City of Albuquerque Stormwater Construction Site Inspection Report

Project Name:	MJ Hospitality Self Storage						
Location:	4100 Yale						
Site Contact Name & Agency	Leo Rojas - ARFA Const.		ESC File No.		G16E095F		
	jasser007@gmail.com		NPDES Id. No.		NMR1000YT		
Inspection Date:	11/08/19	Start/End Time:		10:15/10:25AM			
CoA Stormwater Inspector:	Doug Hughes						
Construction Phase:	Vertical						
Type of Inspection:	Regular	Storm Event	Post Storm Event >0.25"	311/Complaint	Follow Up

Curb Storm Inlet Protection with Wattles

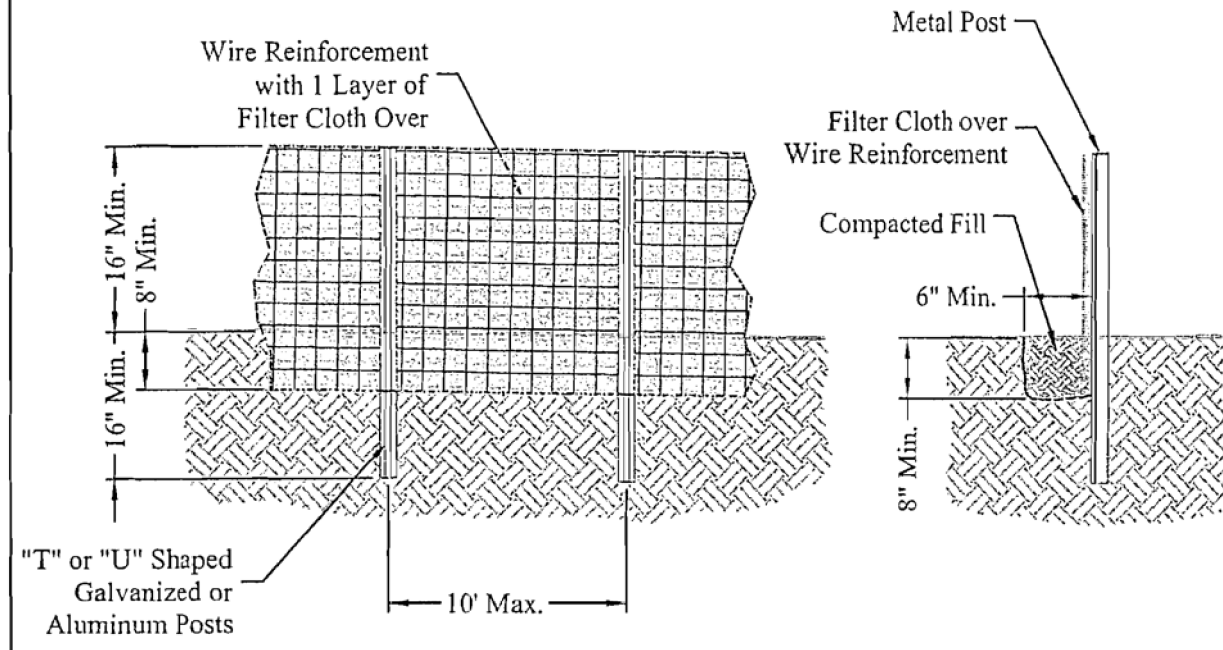
Item Number	Deficiency/ Corrective Action			
1	Concrete wash water in dirt next to lined pit needs removed. Pit needs maintenance.			
2	Selt fence on west side of site not toed in and has holes. Maintenance required.			
2.1	Discharge off site? (Y/N)	Yes		
3	Self Inspection Reports		Latest report Date:	9/18/2019
